Modification of Development Consent

Section 4.55(1A) of the *Environmental Planning and Assessment Act 1979*

Development consent:	SSD 6960 granted by the Planning Assessment Commission on 7 March 2017
For the following:	Construction of the Stage 1B basement including remediation, bulk excavation, interim public domain, interim roadway, services, infrastructure and associated works.
Applicant:	Lendlease (Millers Point) Pty Ltd
Consent Authority:	Minister for Planning and Public Spaces
The Land:	Lot 214 DP 1221076
Modification:	SSD 6960 MOD 3: Increase in non-residential Gross Floor Area within the basement from 26 m ² to 65 m ² and amend the basement layout.

**End of modification
(SSD 6960 MOD 3)**

Approved Section 4.55 (.....1A.....) Modification Application  
 No. 3 Granted on 10/12/2019  
 In respect to SSD 6960  
 Signed H  
 Sheet No 2 of 6

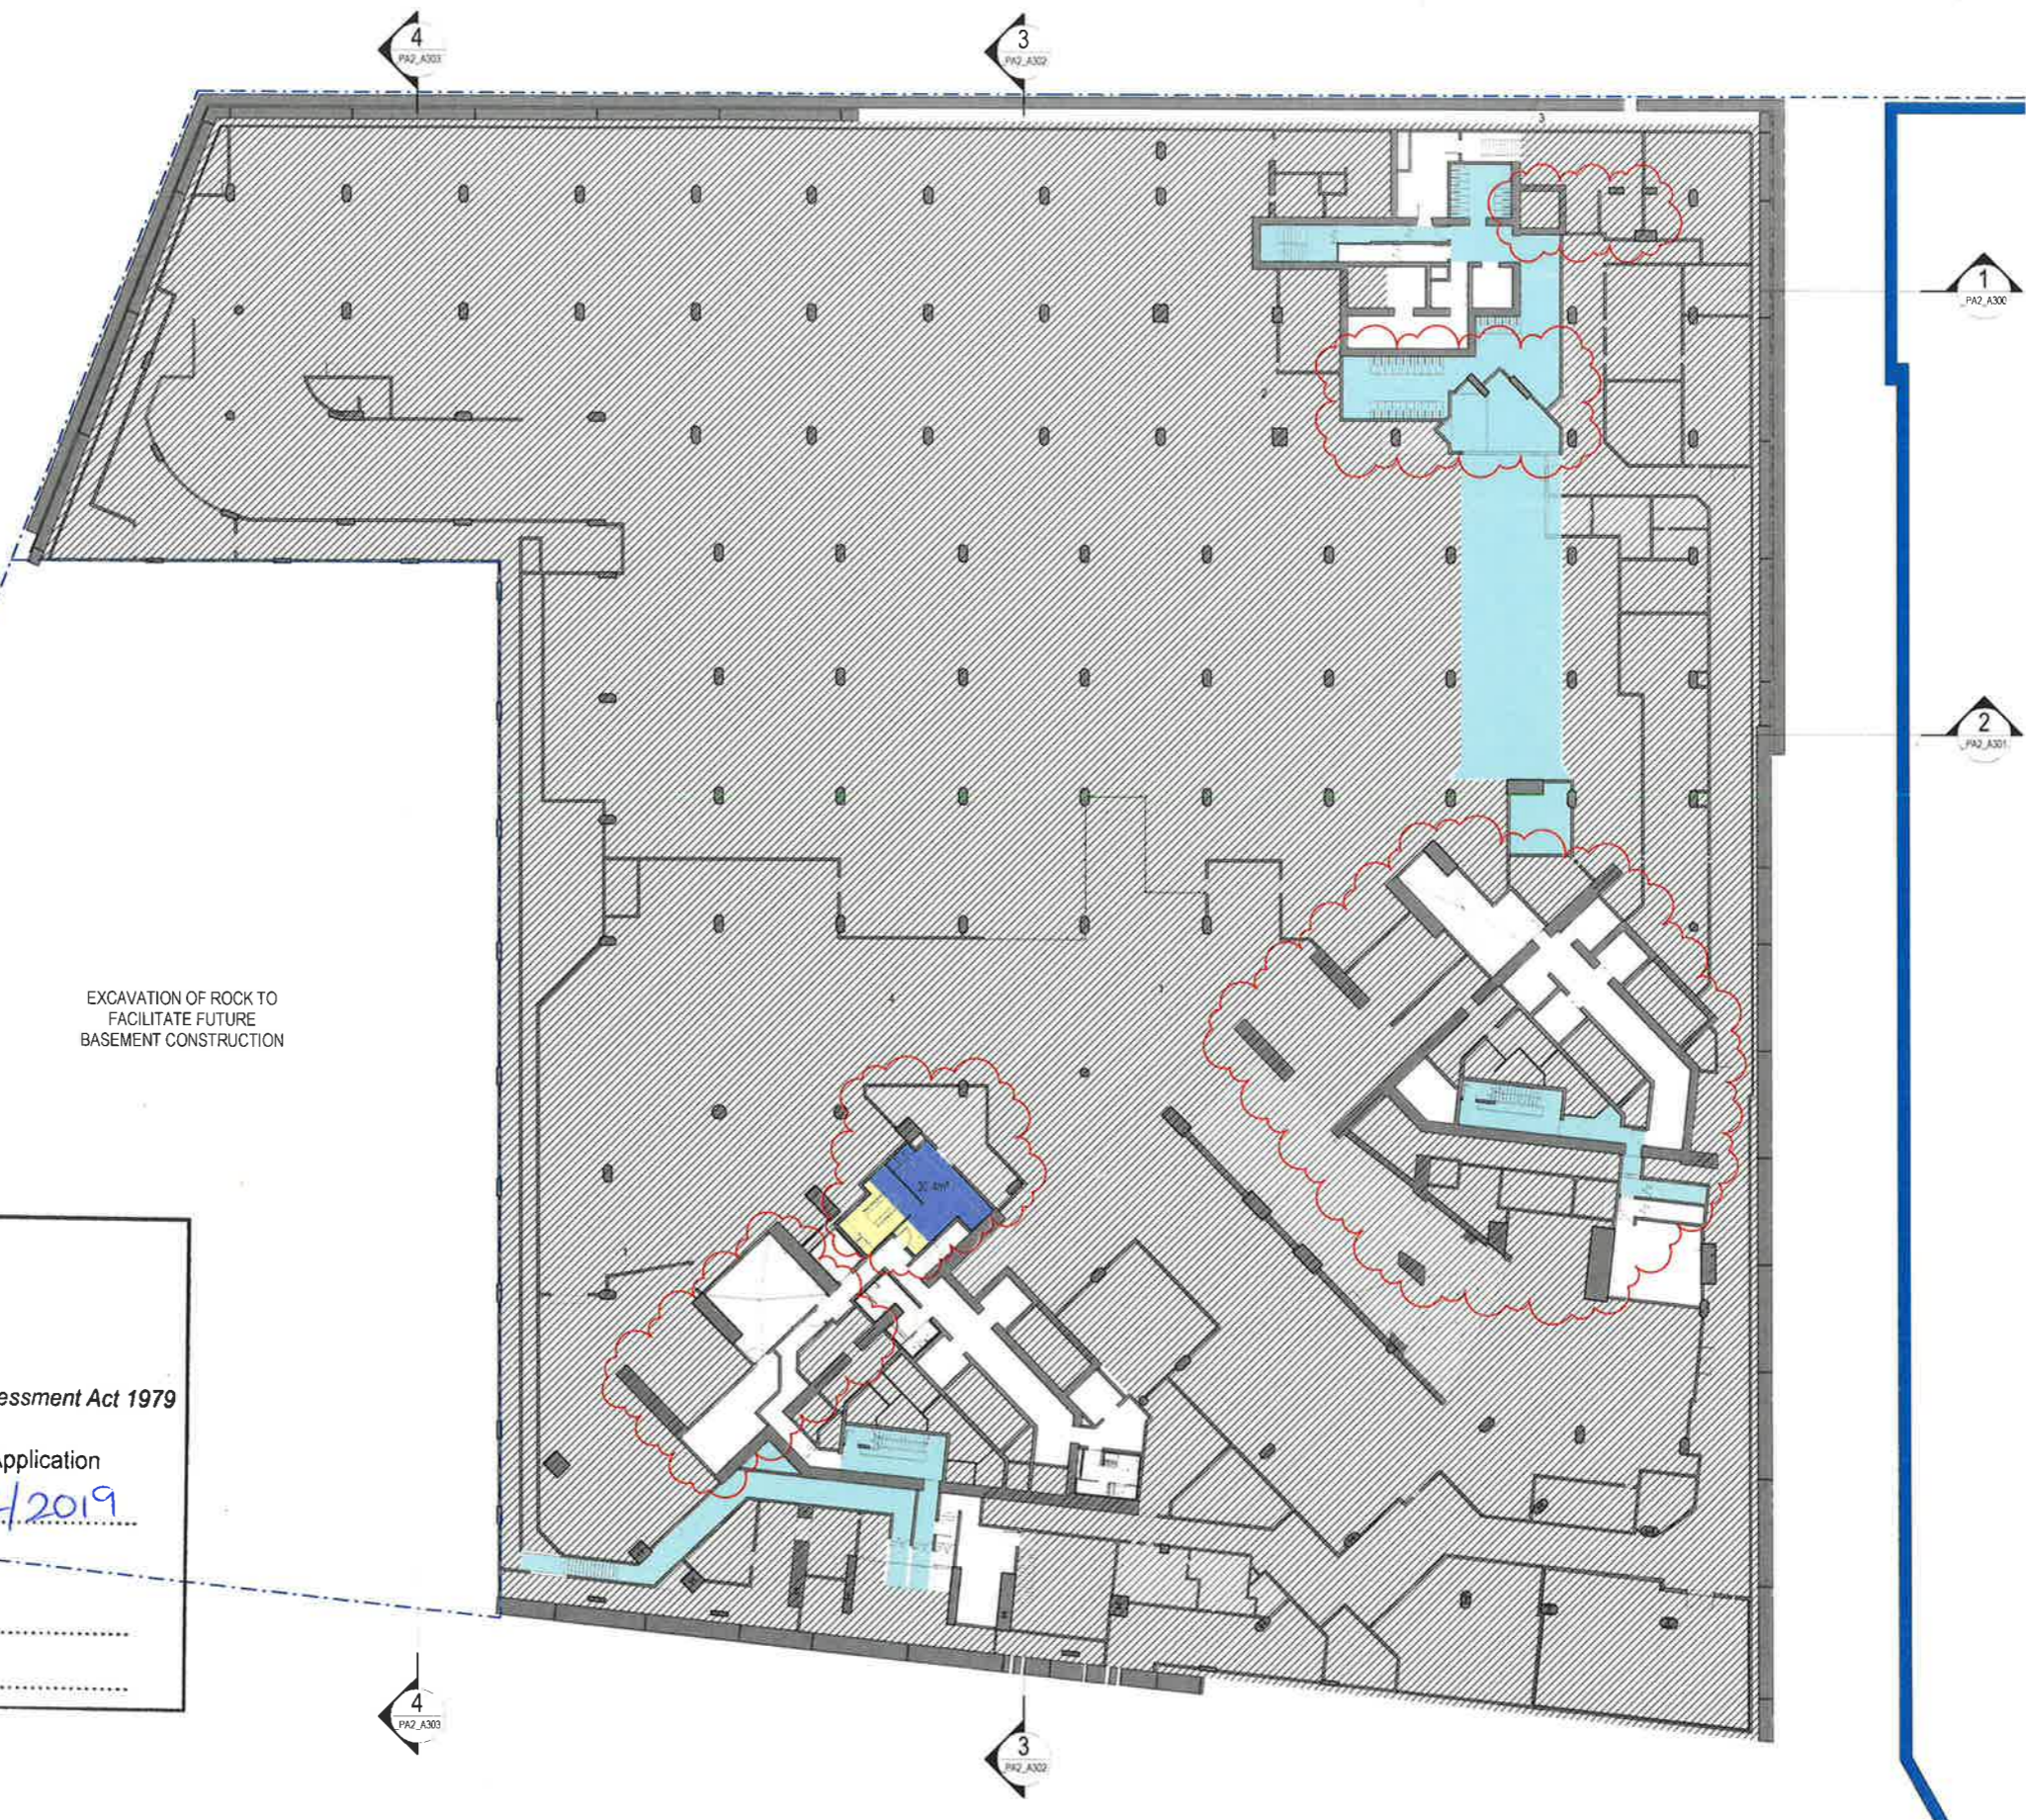
- (d) use of ~~26 m²~~ **65 m²** of gross floor area (GFA) within level **B0 and** B1 of the basement for basement uses ~~and additional GFA for end of trip facilities on level B0~~;

Prior to the issue of the relevant Construction Certificate, documentation including plans shall be submitted to the satisfaction of the Certifying Authority identifying the location of areas for bicycle parking, and the location and ~~total gross floor area~~ for end of trip facilities (storage, change rooms and showers) within level B0 **and B1** of the basement.

The bicycle parking areas shall be provided in the ~~upper levels~~ **on Levels B1 and B0** of the basement, grouped together in convenient, accessible areas close to main entries. The areas shall be sized to accommodate the provision of bicycle parking and end of trip facilities (storage, change rooms and showers) in accordance with the rates identified in the Barangaroo Concept Plan MP 06_0162 (as modified).

A Registered Surveyor is to certify that the Gross Floor Area (GFA) of the development approved by this consent does not exceed ~~26 m²~~ **65 m²** for basement uses on level B1 **and B0**, ~~and an additional allocation of GFA for end trip facilities on level B0 as required by Condition B28~~. Details shall be provided to the Certifying Authority demonstrating compliance with this condition prior to the issue of the relevant Occupation Certificate.
